23 November 2010

**Major Project 10_0107 – Residential Development – Buildings 1, 2 & 3
61 Mobbs Lane - Epping - Channel 7 Site (Epping Park)**

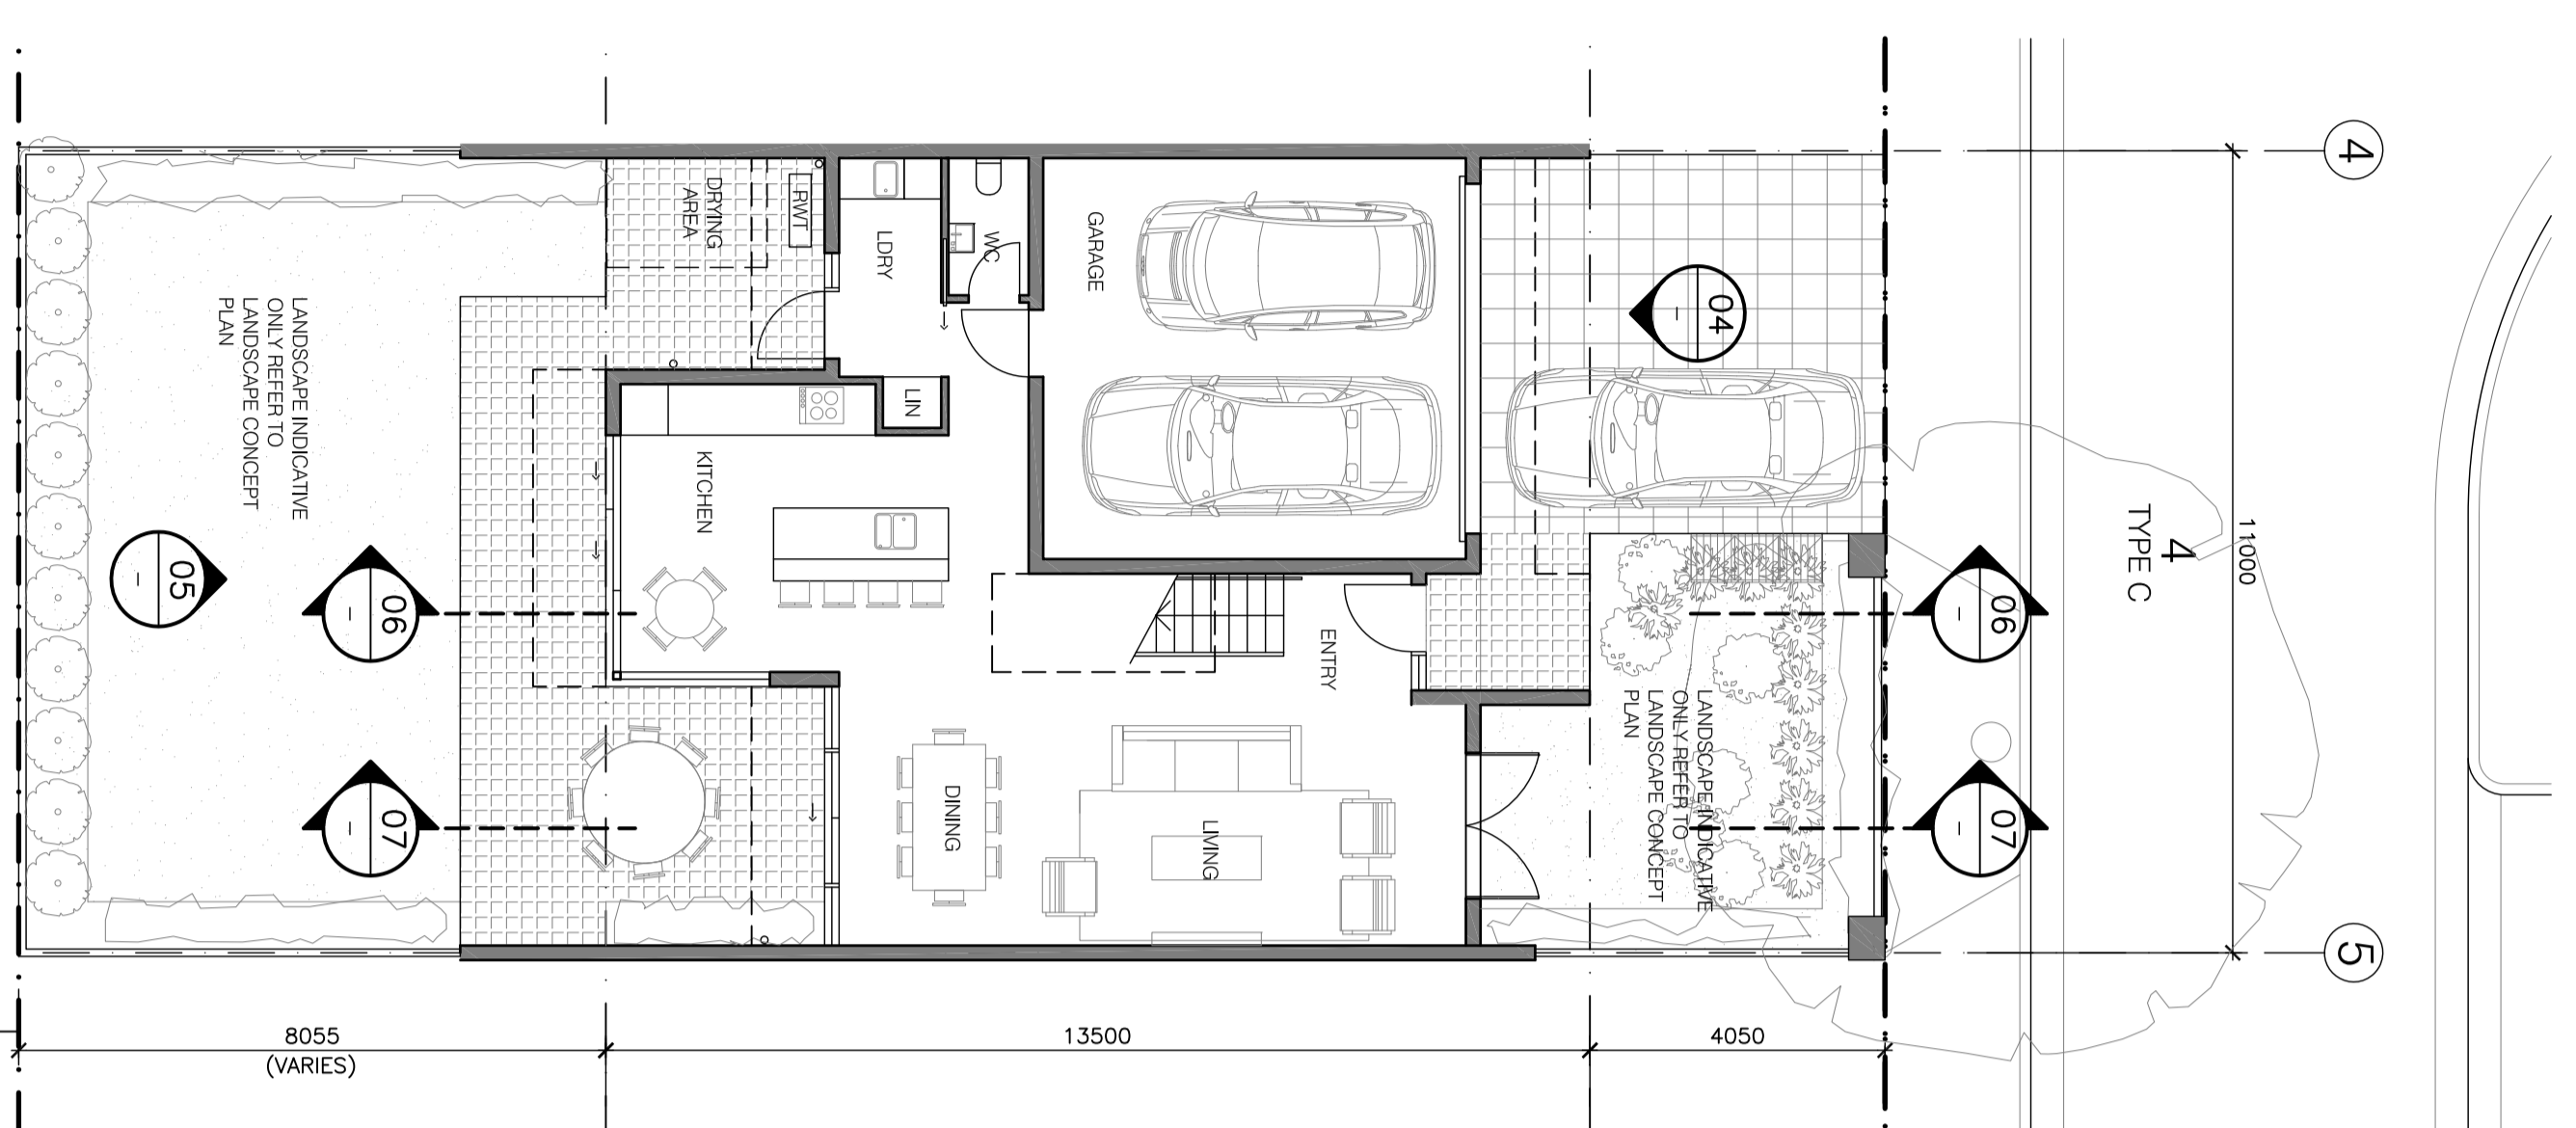
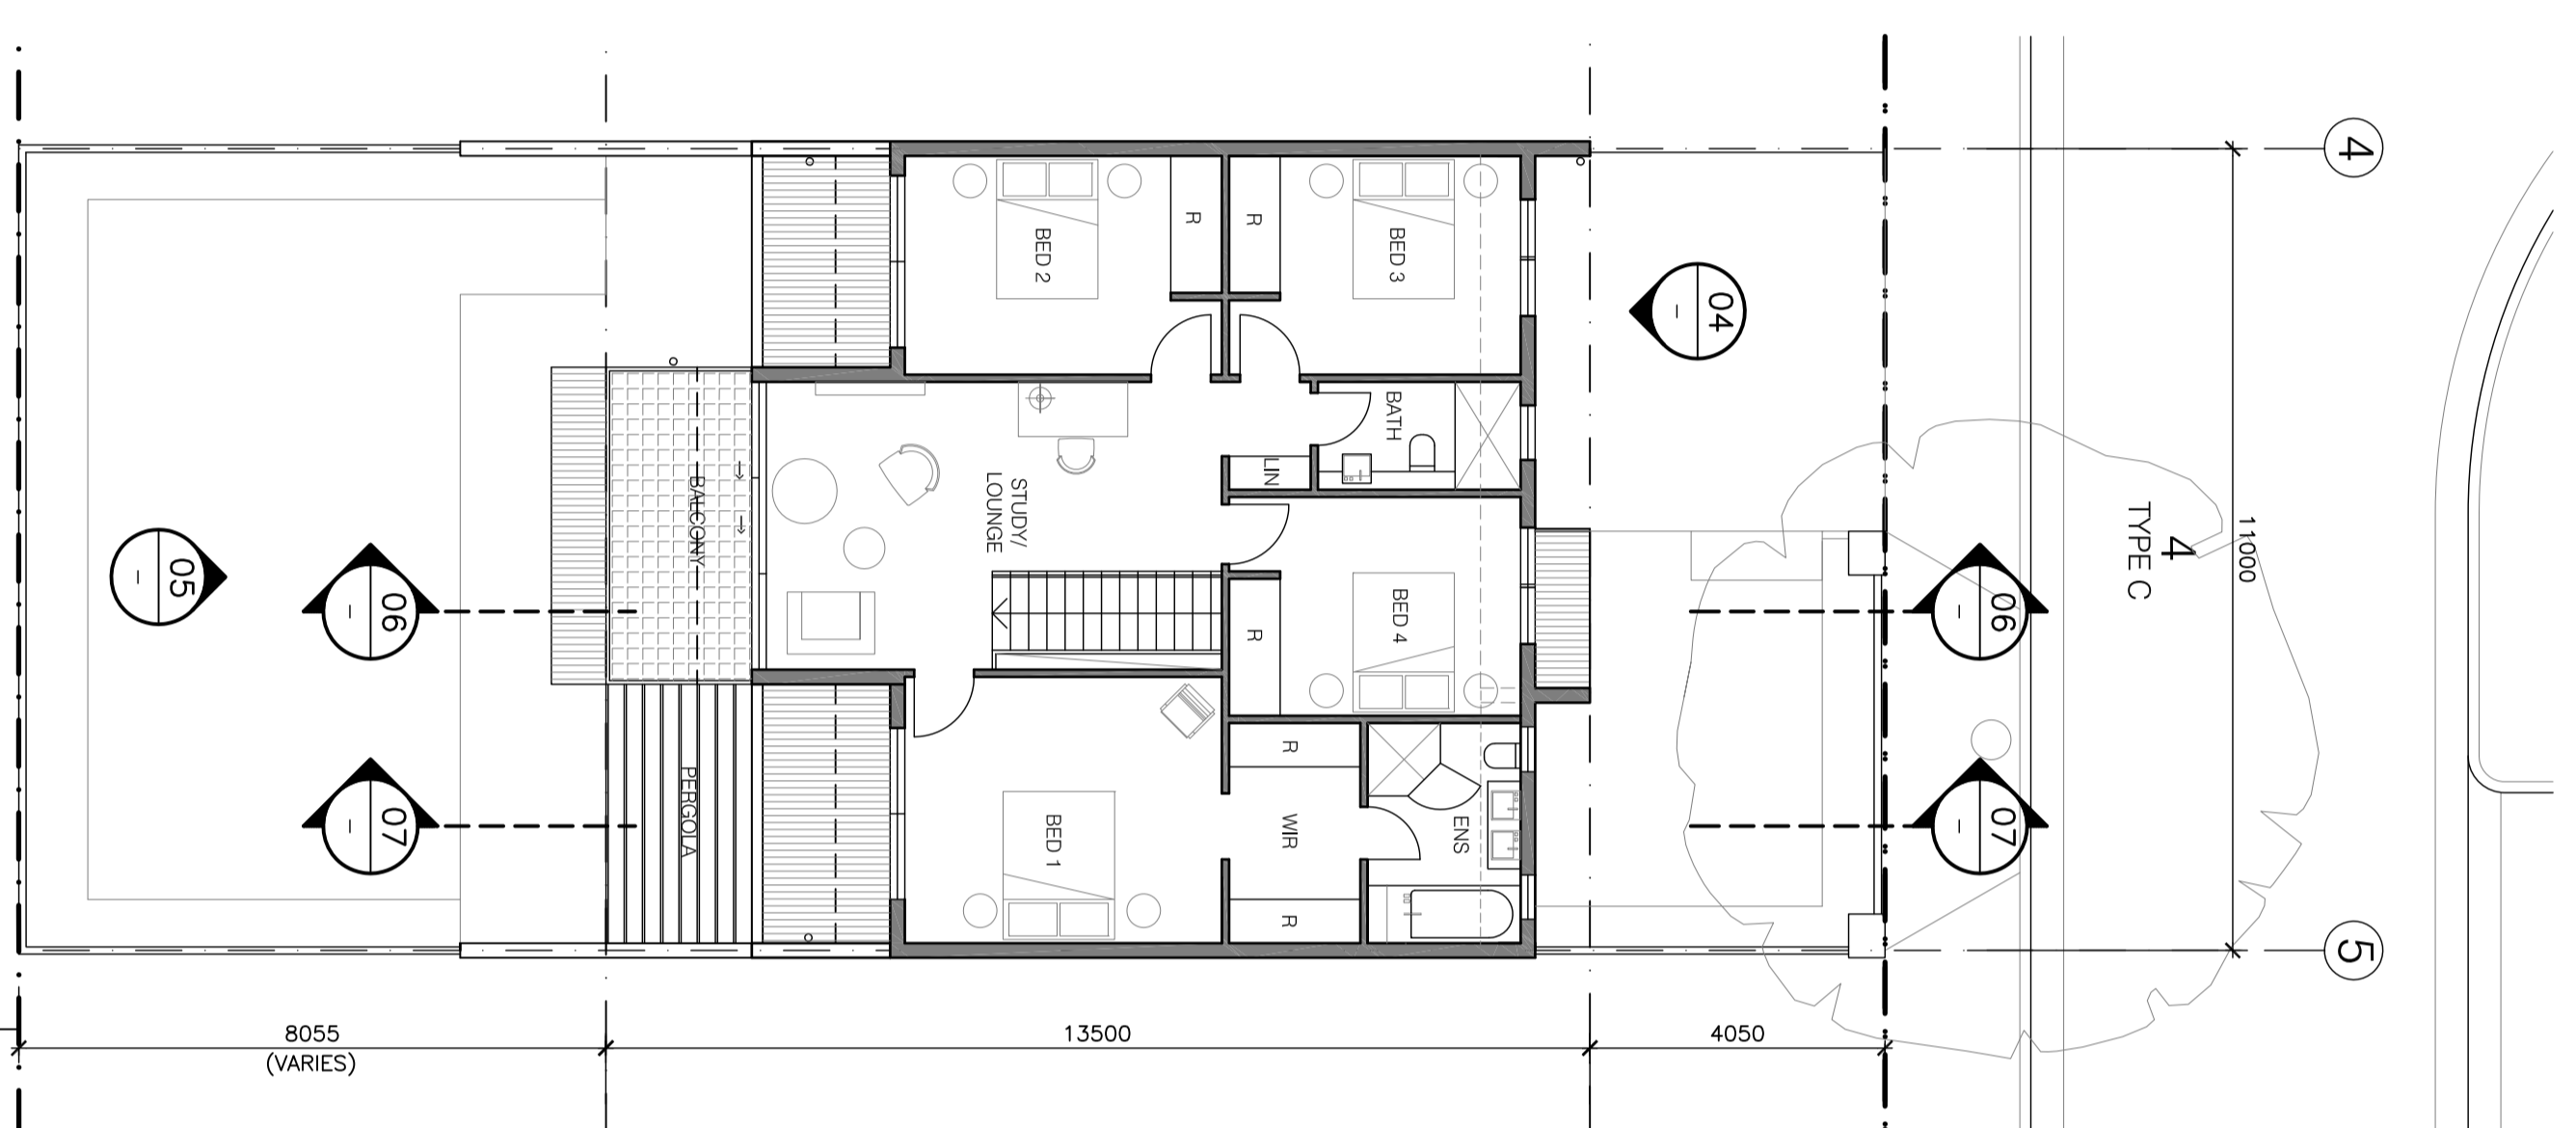
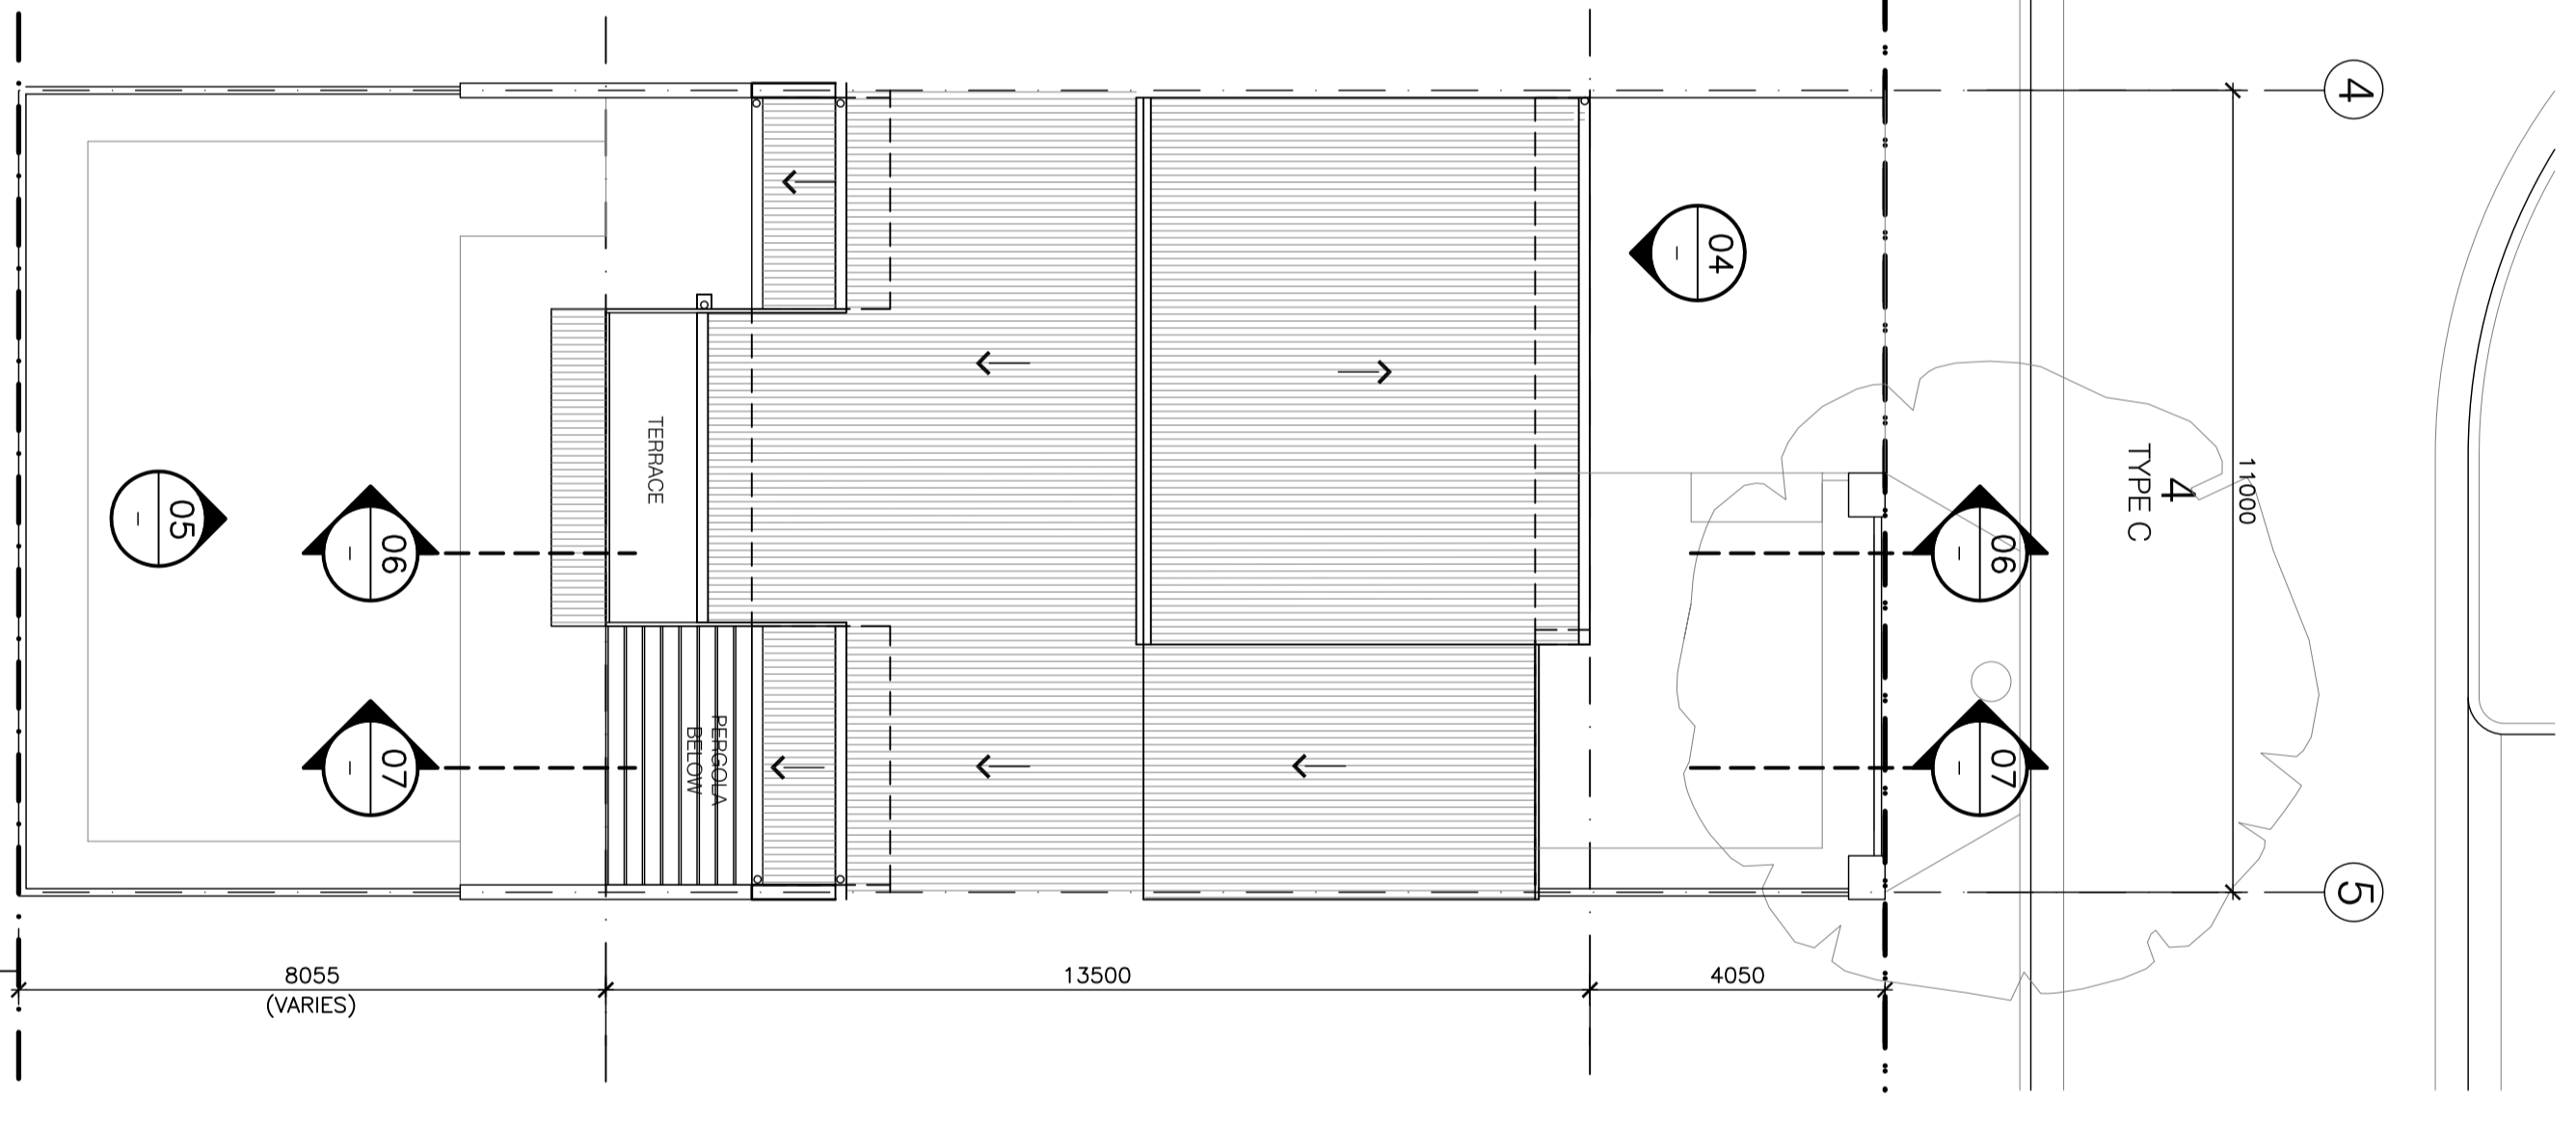
It is noted that the townhouse development has a continuous frontage of over 130m. This design conflicts with Parramatta Development Control Plan 2005 which restricts frontages of multi unit dwellings to a maximum of 20m. This is required to provide visual cohesion, continuity (including rhythm and spacing) and distinction of buildings. It is considered that the massing needs to be broken up into separate building elements.

Concern is raised with regard to the garage dominance of the proposed townhouse development. Parramatta Development Control Plan 2005 requires garages be located a minimum of 300mm behind the building line of the dwelling and be less than 50% of the front elevation. The proposed garages do not comply with these design standards and will effectively result in dominating the visual appearance of the dwellings, and thereby the internal streetscape.

The 1st floor balconies at the rear should be deleted due to the potential overlooking impacts on the adjoining properties on Edenlee Street. The balconies do not serve any benefit as private open space and their deletion would not result in any loss of amenity to the future occupants of the site.
